Sea Link

Document: 6.15 Scoping Opinion 2022

SCOPING OPINION:

01 December 2022

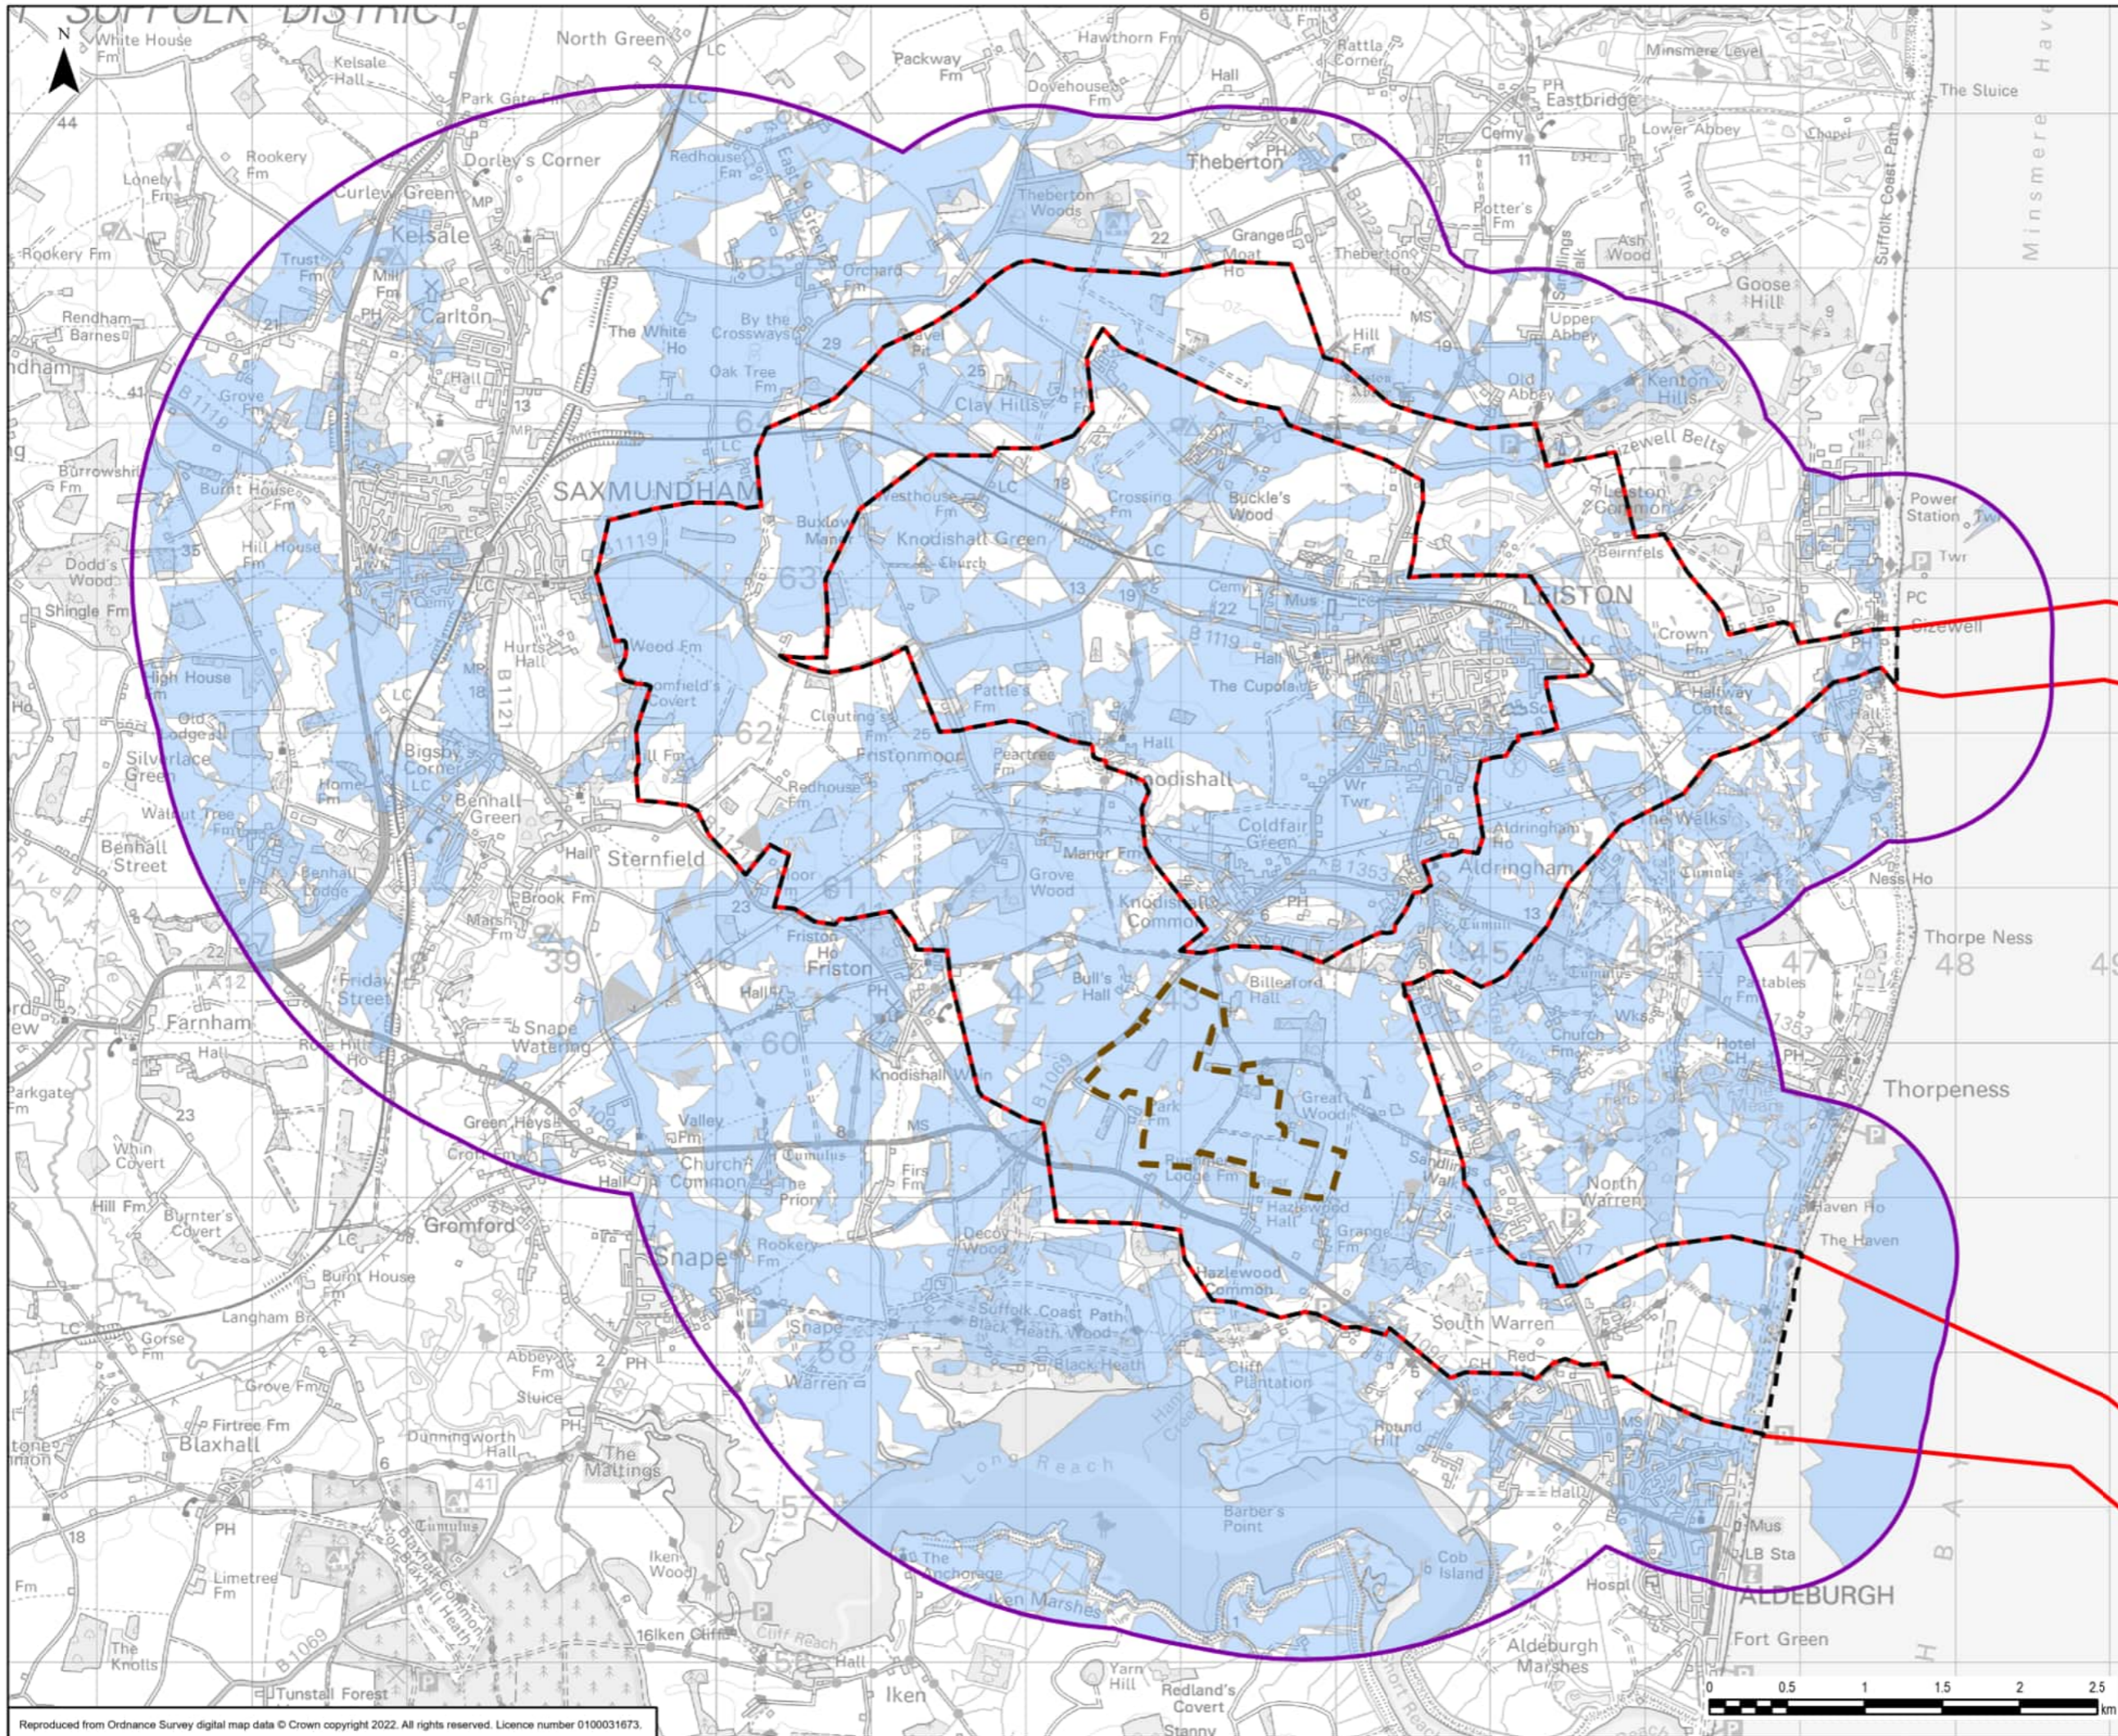
3.1.8	Volume 1, Part 2, Paragraphs 2.2.4.18 and 2.2.4.19 and Figure 2.2.5	Seascape Character	Figure 2.2.5 includes regional seascape character area SCT01: Inland Navigable Waters, which is not identified in the chapter text. The ES should include consideration of all relevant seascape character types.

Scheme: SEA LINK  
 Document Title: STATUTORY DESIGNATED ECOLOGICAL FEATURES - SHEET 1 OF 5

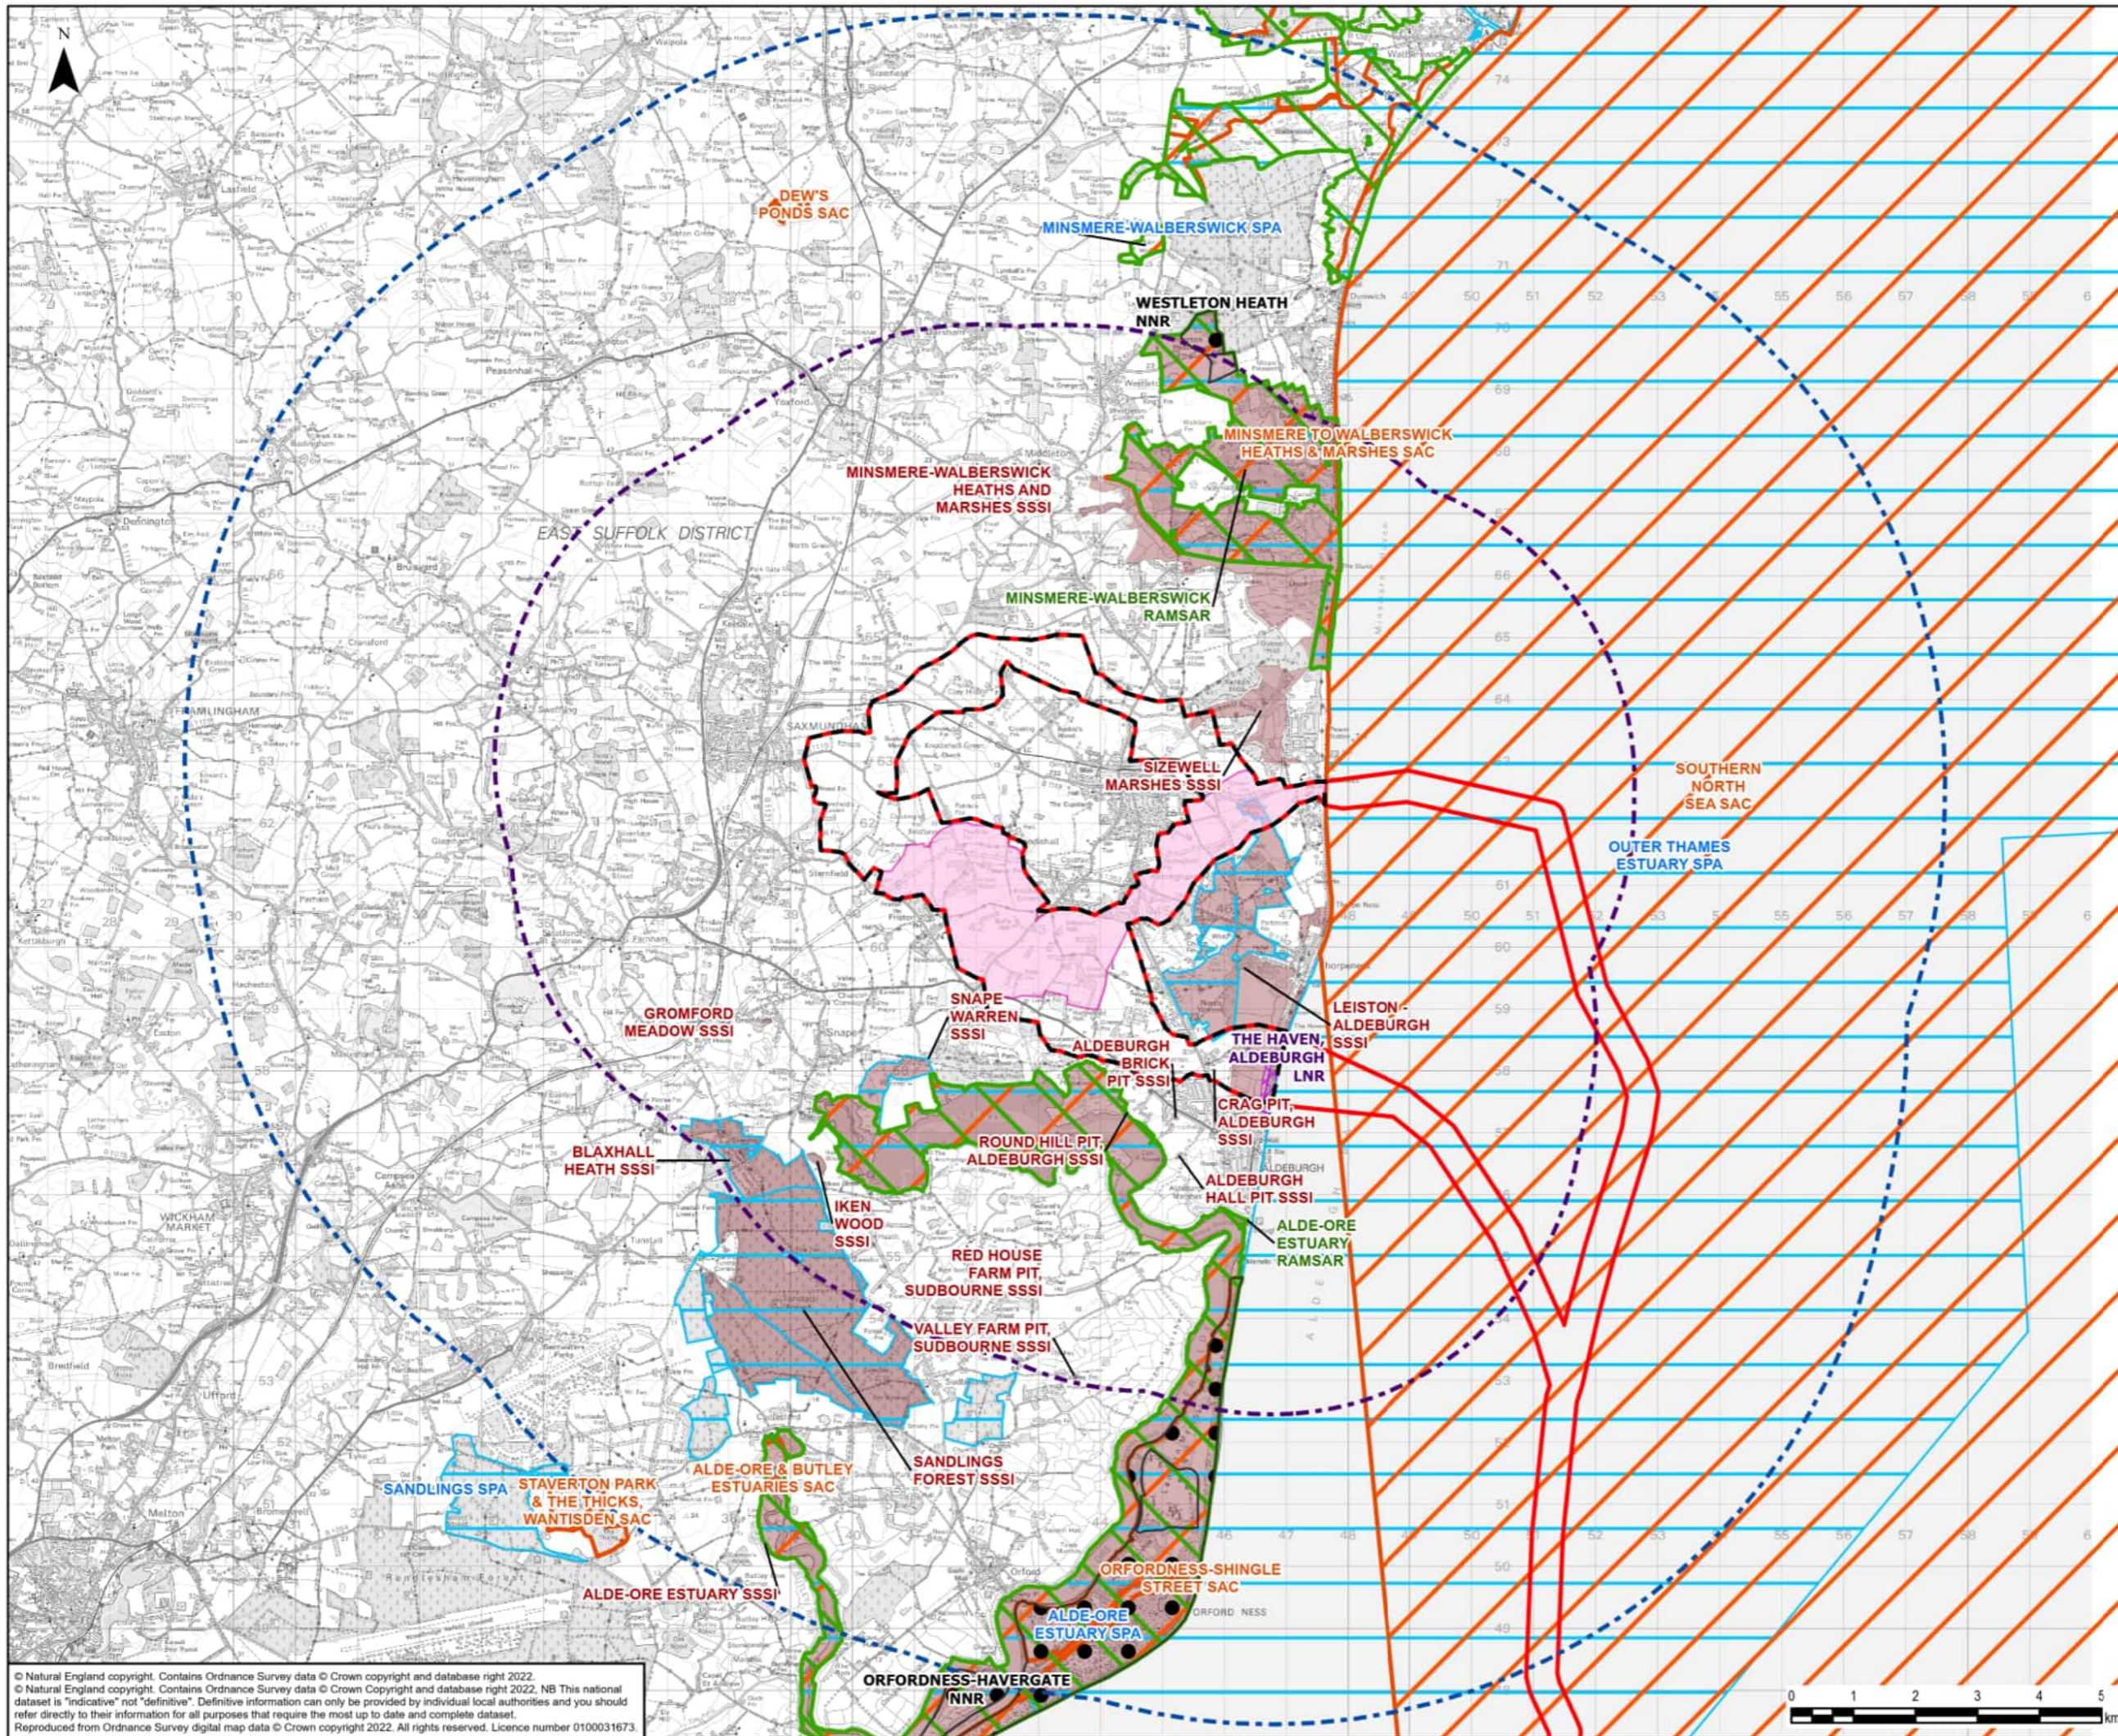
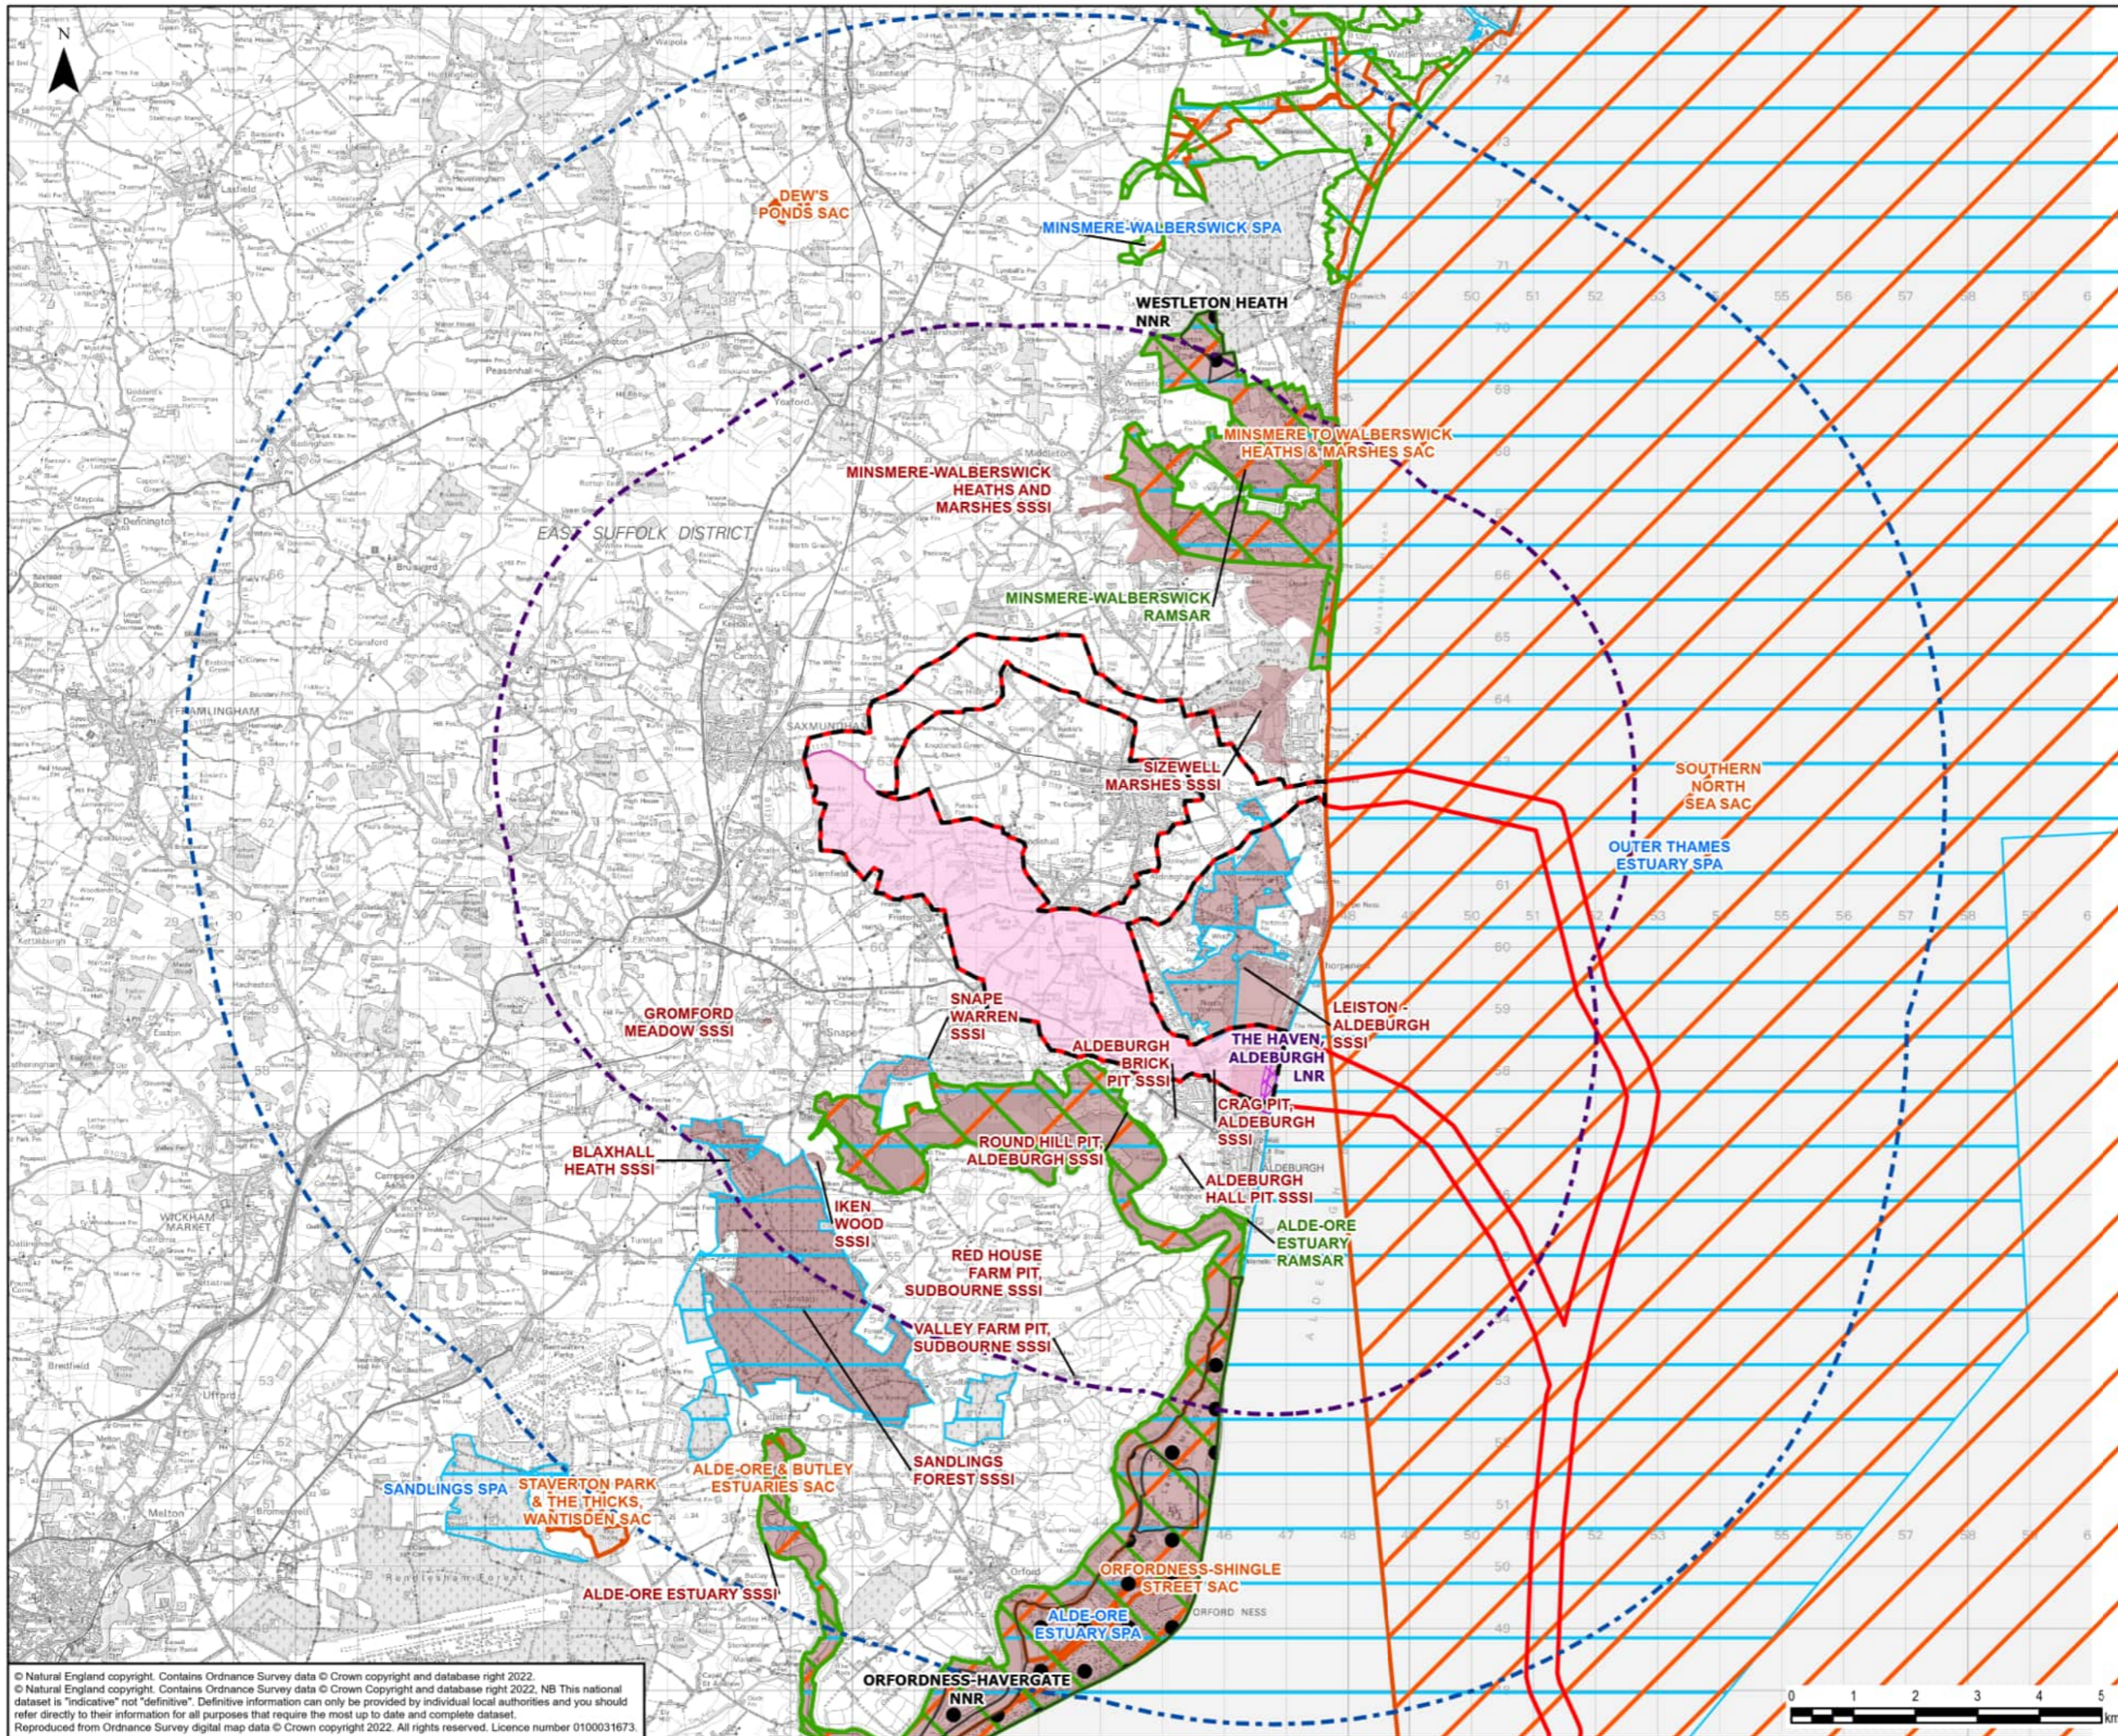
ID	Ref	Description	Inspectorate's comments
3.2.2	Volume 3, Figure 2.3.1	Figures	The location and extent of Sandlings SPA is not clear from Figure 2.3.1. Figures accompanying ES should clearly show and label the location and extent of designated sites.
